756 Forest Ave., BP# 2016-02373

City of Portland Mail - 756 Forest Ave., BP# 2016-02373

PLANS - 756 FOREST AVE.		
SCALE: 1/4" = 1'	APPROVED BY:	DRAWN BY: W. Staley
DATE: 8/9/16		REVISED
Rich + Cindy Meoli		
		DRAWING NUMBER: 101

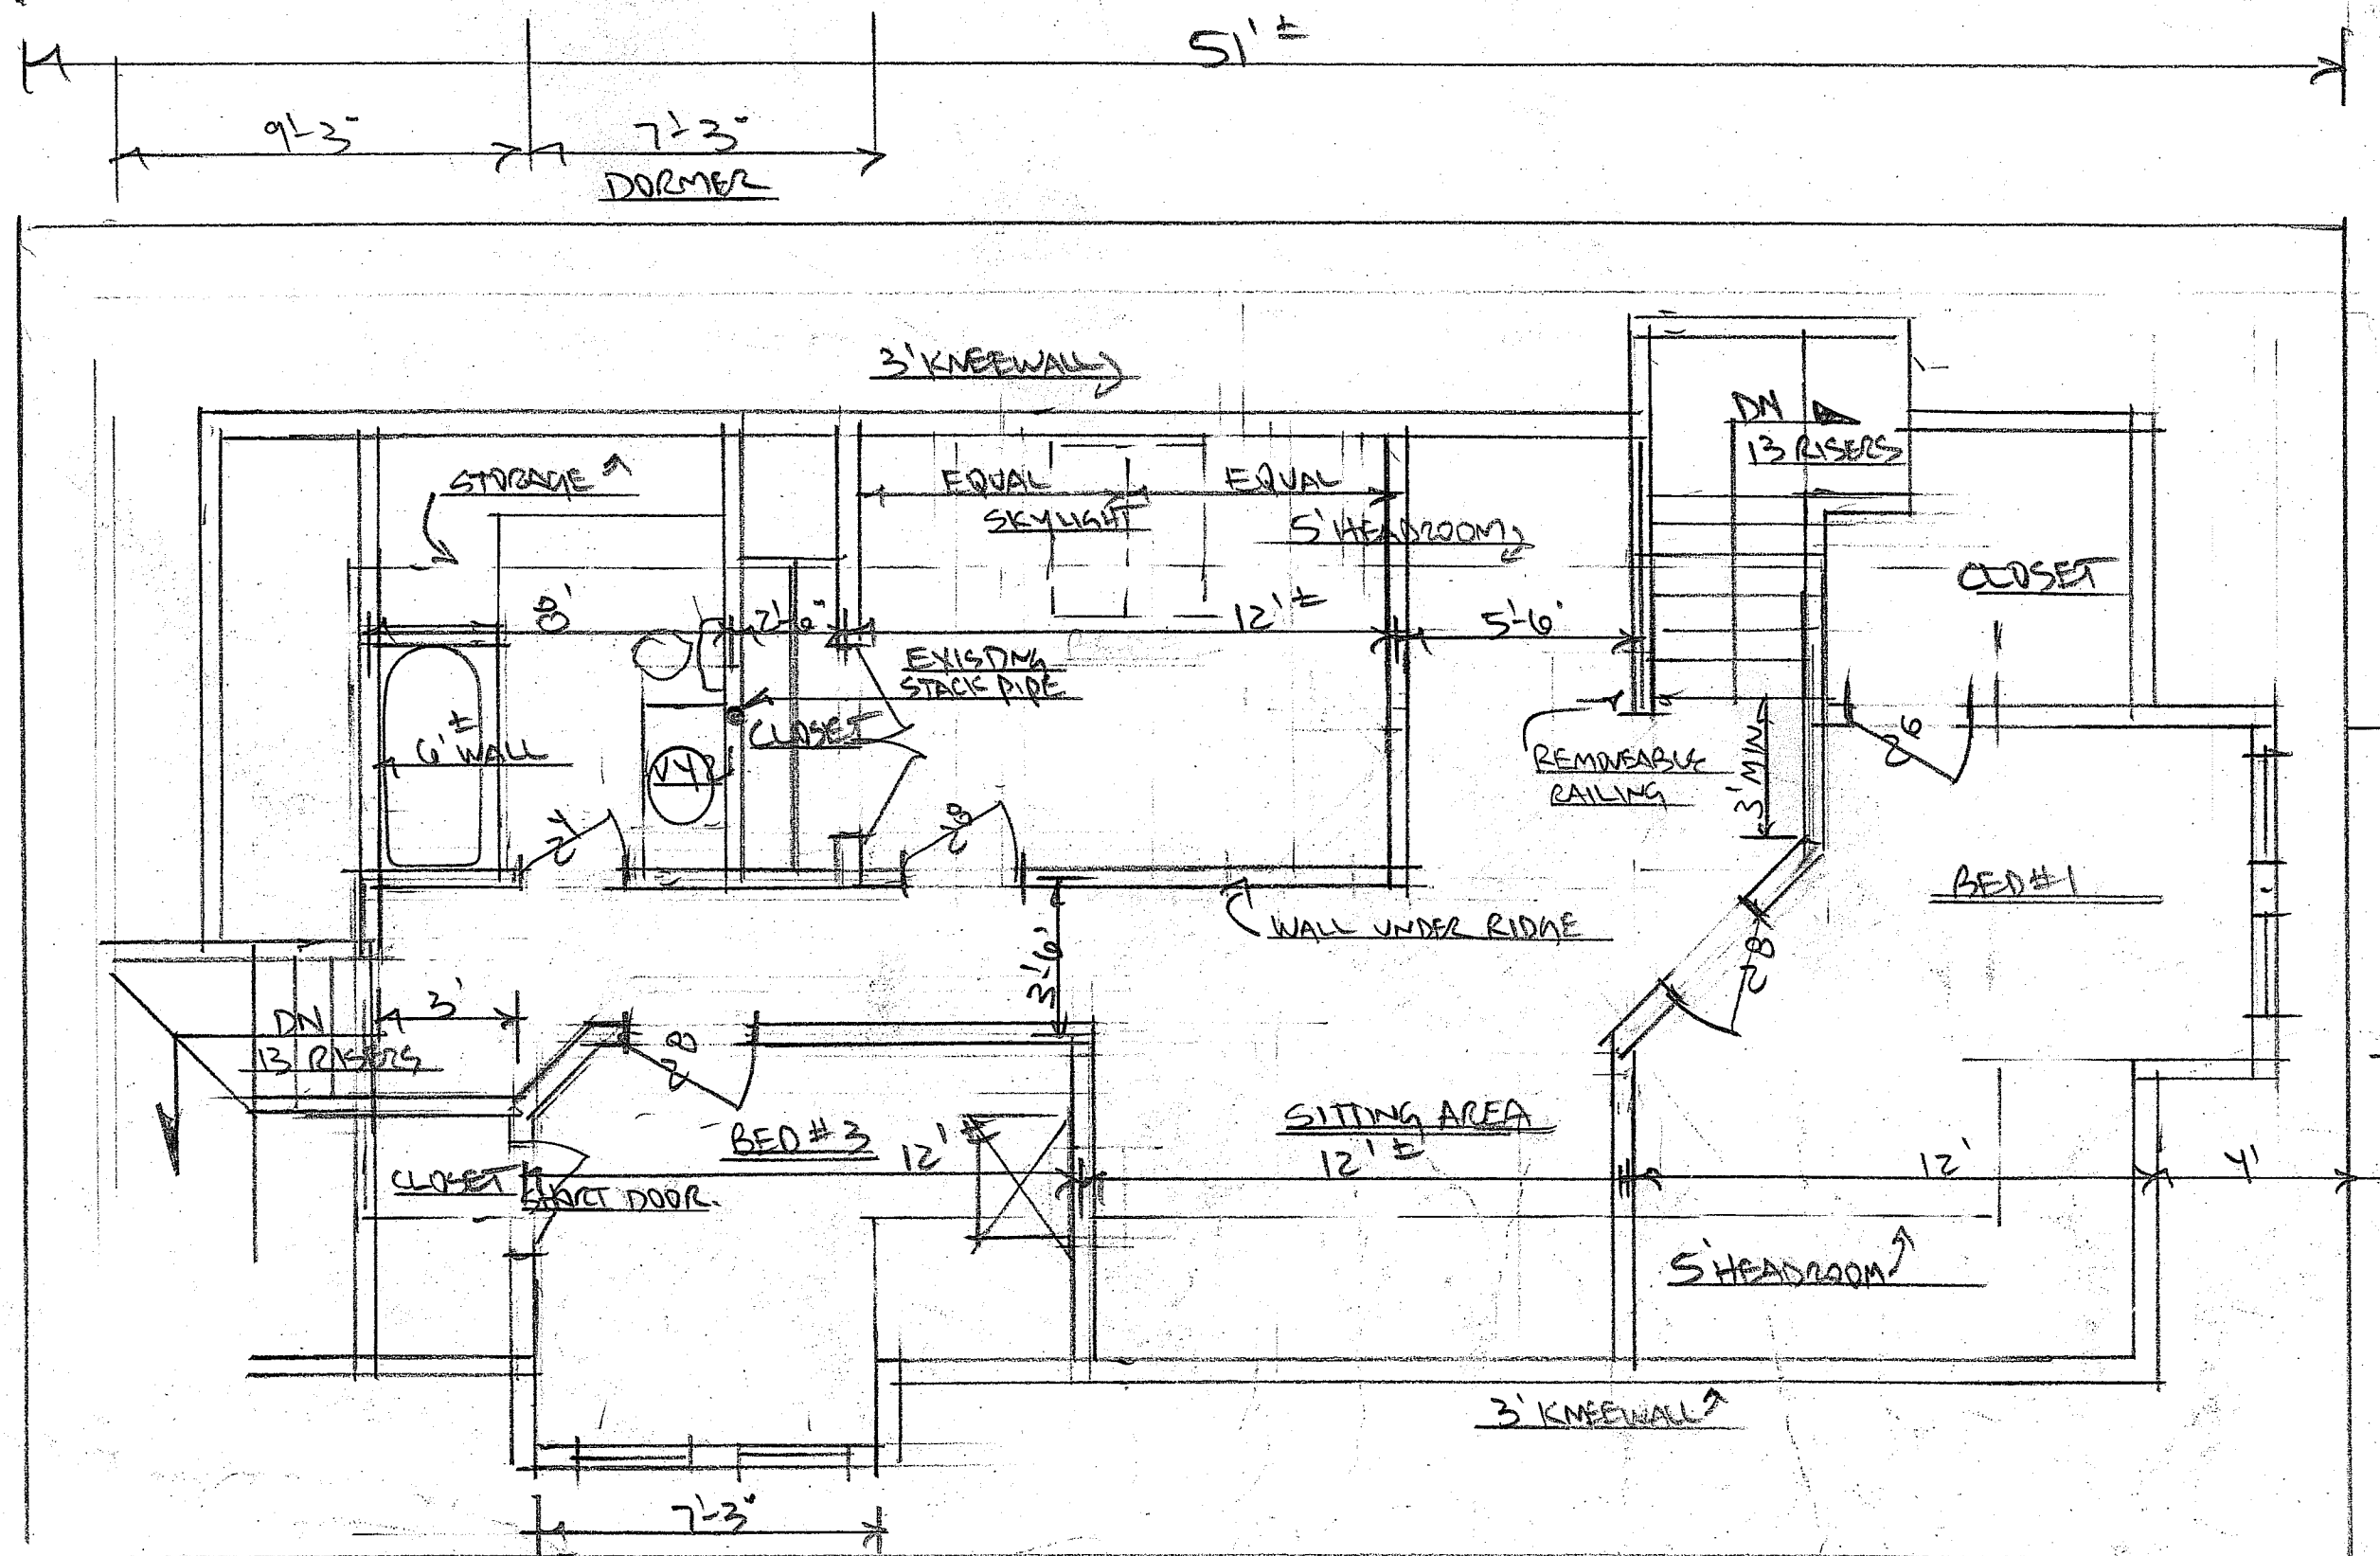
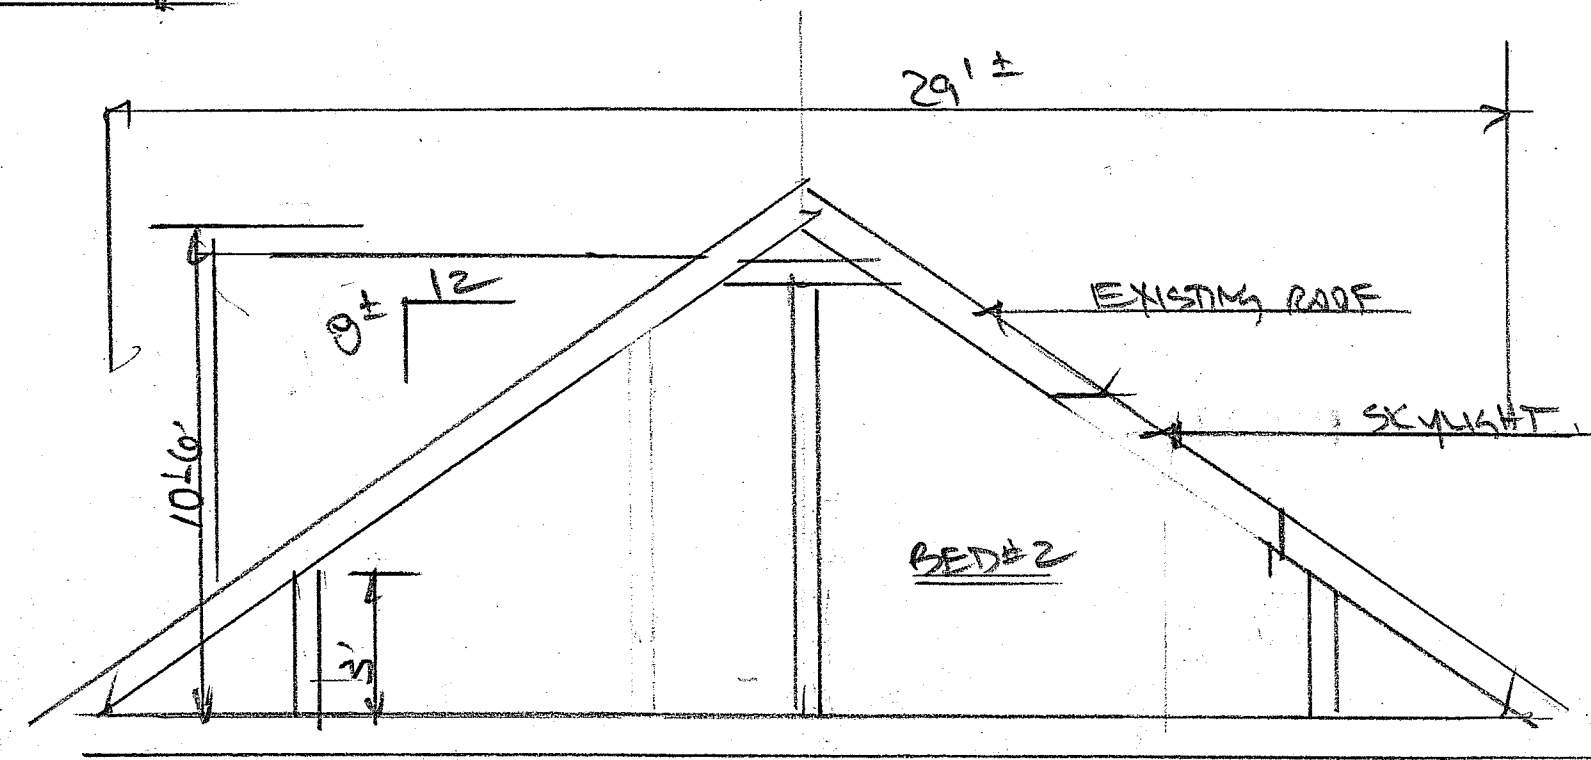
1. Provide a scope of work or further description on the construction elements, ie. is the skylight new (egress), any new windows, insulation, smoke/carbon monoxide detectors, etc.
2. One egress size window is required in all bedrooms - please provide details
3. The section drawing needs to show the required ceiling height at the plumbing fixtures
4. Has the floor load been determined to comply with a habitable space, 30-40 lbs/psf

Thank you for sending this information. On the floor load, with the existing 2 stairs accessing this level, it seems this would have been built with consideration for a habitable load as opposed to an inaccessible attic, which would be considered uninhabitable with limited storage load.

1. New skylight, 4 new windows, 5 in open cell foam for air tight R-40, Carbon/smoke detector in 3rd floor hallway, smoke detector in all bedrooms. New exhaust fan in bathroom, new shower, sink and toilet.
2. Egress skylight(31 x 46) in bedroom 1, 1 -(31 x 40) double hung and 1 - (31 x 40) egress casement in bedroom 2, 1 - (31 x 40) double hung and 1 - (31 x 40) egress casement in bedroom 3.
3. 7 ft plus ceiling height at sink and shower, 6ft 8in at toilet
4. Existing structure code should be "Grandfathered" - 3rd floor level was used as an office with storage

- a. Have not increased the load
- b. Have not decreased the capacity
- c. Have not changed the use, it was always residential

For a 40 lb/psf load, at a 29' house width with center bearing wall, this would be a minimum of a 2 x 8 joist, 16" on center, rough sawn lumber. Being as the floor will be opened up for the bathroom plumbing, I will put a condition of approval that the dimension and spacing of the joists needs to be confirmed with the inspector.
